Recommendation Report for Listed Building Consent for Alterations, Extension or Demolition of a
Listed Building

REF NO: P/123/20/L

LOCATION: Pennicotts Farm
Pagham Road
Pagham
PO20 1LN

PROPOSAL: Listed building consent for the demolition of existing conservatory to southern side of building & general repair & maintenance of external brickwork & roof coverings, insertion of 2 No conservation style rooflights to the rear valley roof, & formation of 2 No sets of double patio doors within existing window openings on the northern elevation. Internal alterations comprising the removal of partition walls, reinstatement of wooden balustrade to staircase, and general repair, maintenance and refurbishment.

Title	Side Elevation PROPOSED
Client	Mr. S. Cox-Rusbridge

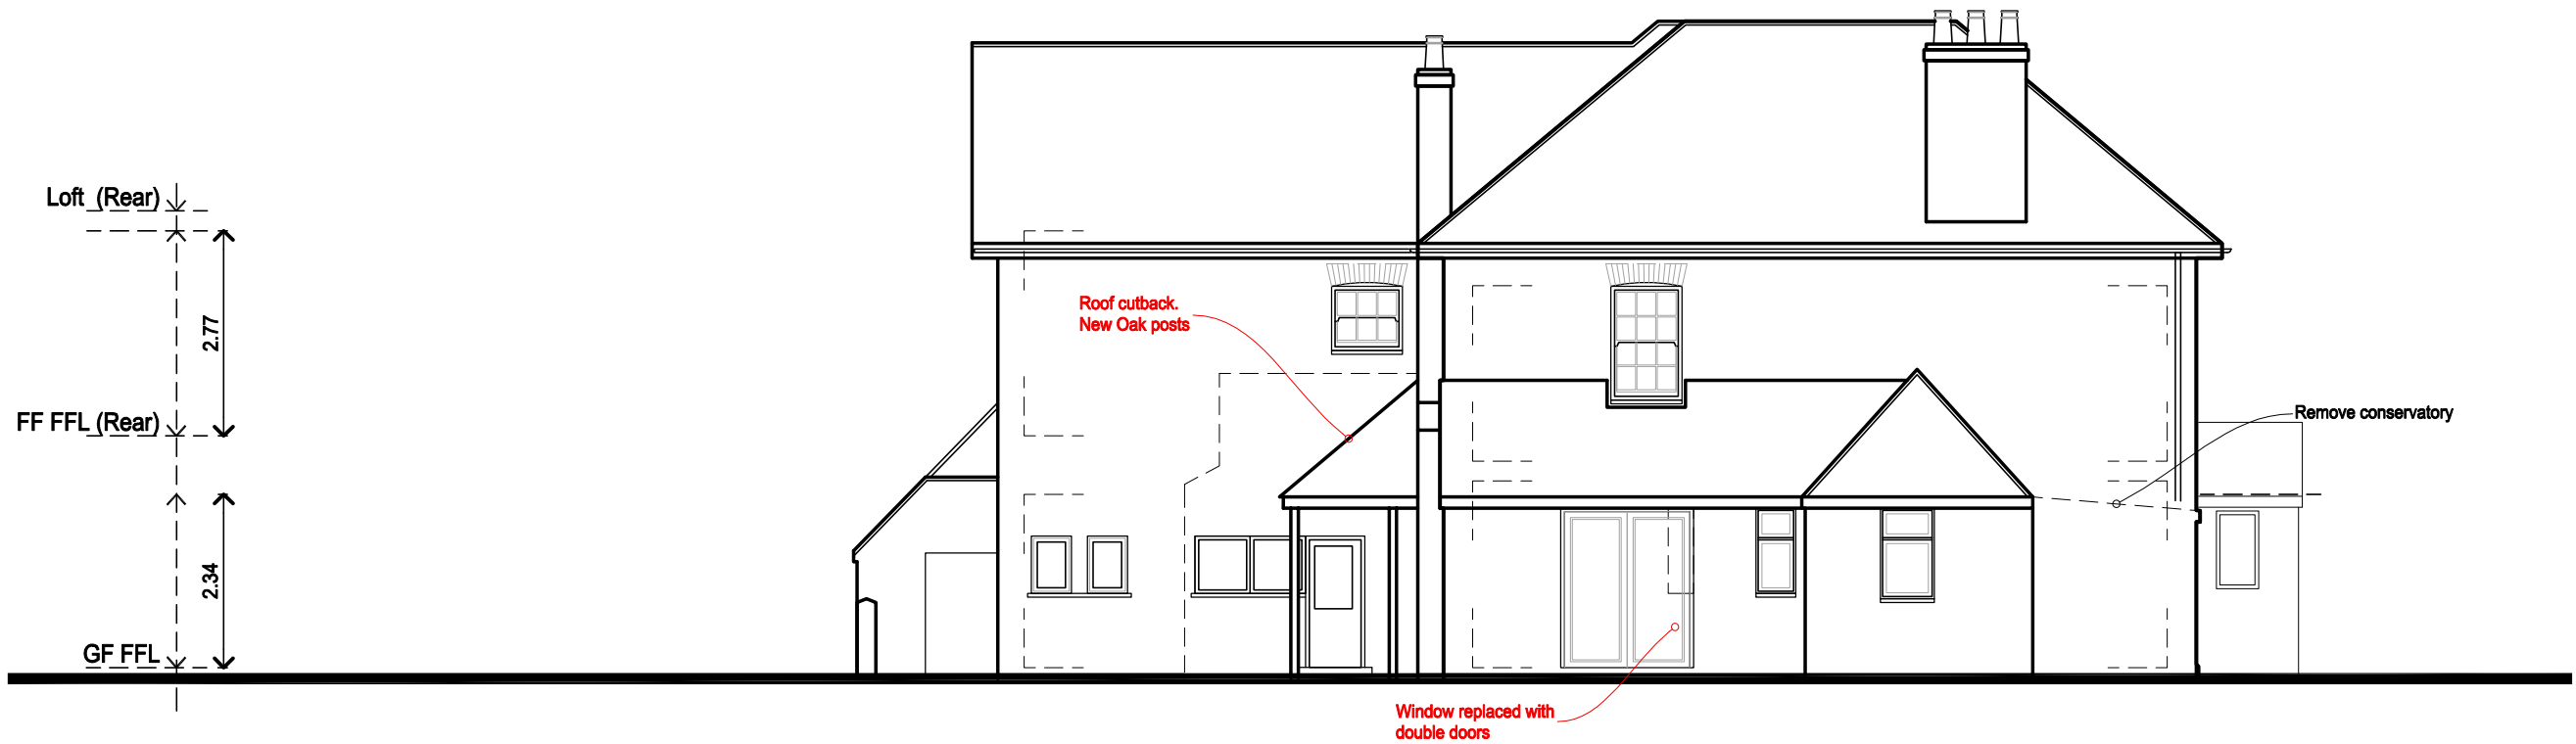
Work that involve the general repair and maintenance of external brickwork and roof covering are acceptable subject to the nature of the works and material to be used. The insertion of 2 conservation style roof-lights to the rear valley roof and formation of 2 sets double patio doors will result in the removal of historic fabric. However, the amount of fabric affected is small; design of replacement doors is acceptable (side elevation).

Details of the external doors/French doors along with their treatment should be provided if approved.

- 4 No development shall commence until detailed drawings of the external doors/French doors will be provided along with their treatment.
